Online Comment

Application H15-0289-17
Location Land off St Margaret's Quadring Spalding
Proposal Residential development of up to 34 dwellings

Illustrative Site Layout 1:500

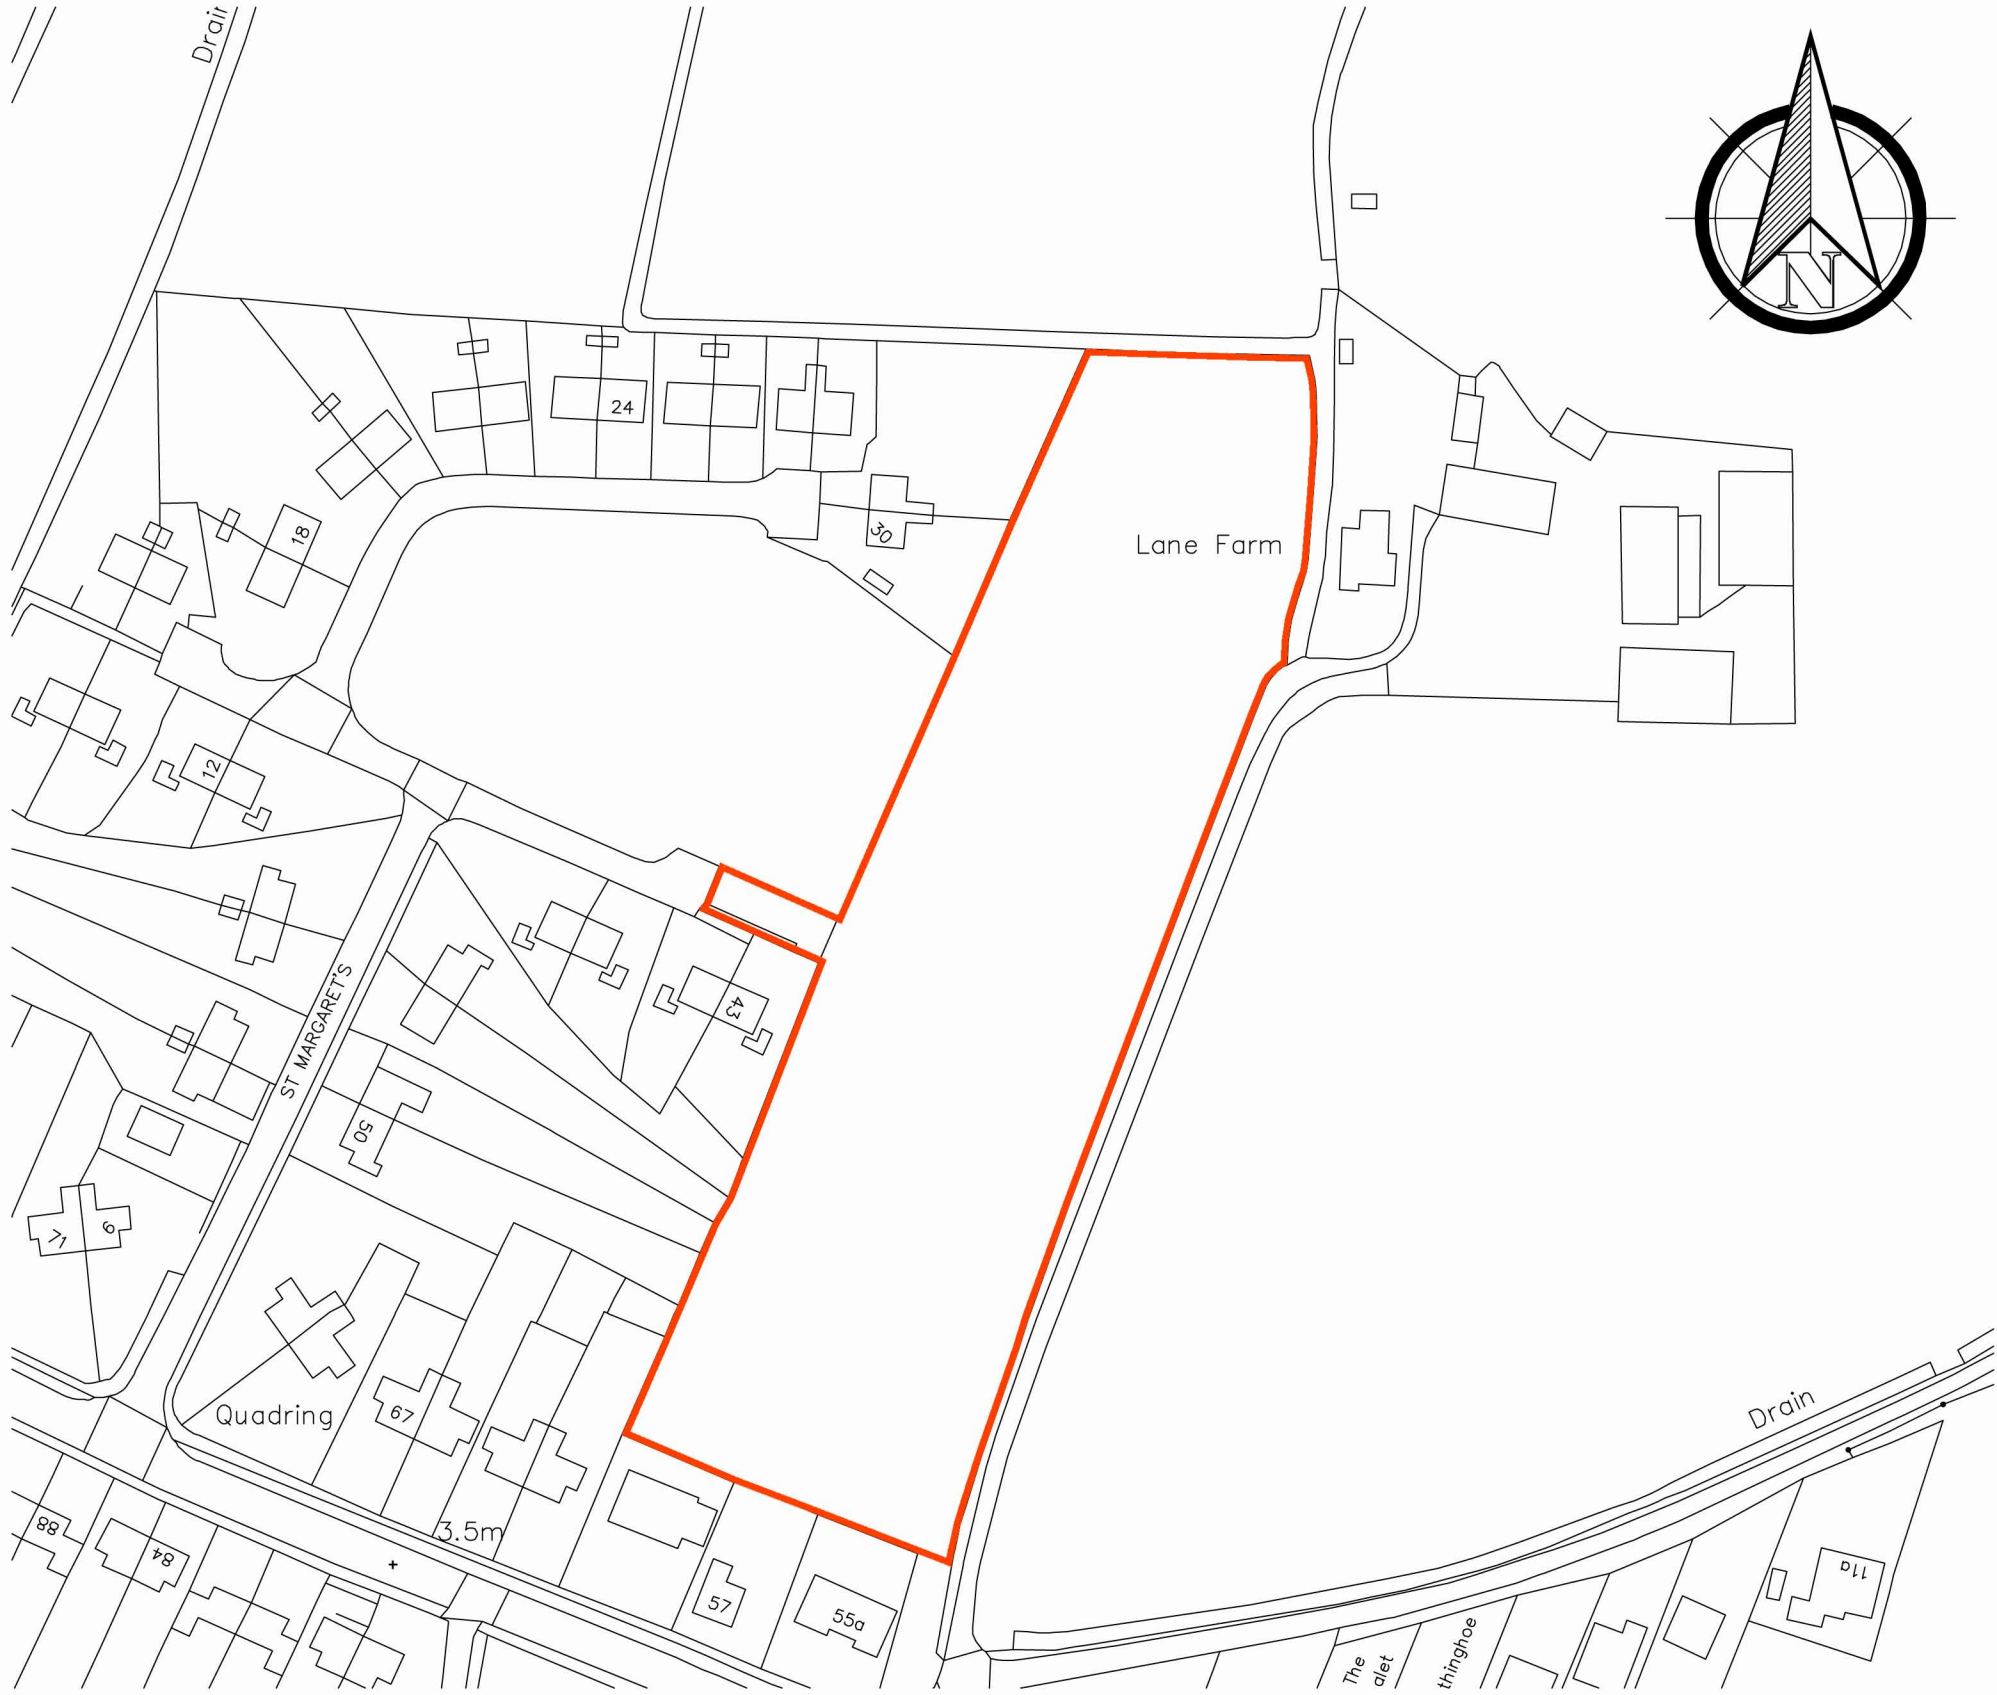
Access roadways to all residential properties should be constructed to an adoptable standard under an agreement with Lincolnshire County Council so that they will become public highways. This will enable refuse/recycling collections to be carried out from outside individual properties without the need for communal collection points at the point where private driveways adjoin public highways.

If not utilised correctly communal collection points become areas of dispute for residents of adjacent properties.

Should it be agreed that communal collection points will form part of this development the position of those collection points should be made clear to the potential occupiers of the properties nearby. This should not just be to the properties that will need to use the collection points but also the ones who will have them outside their properties.
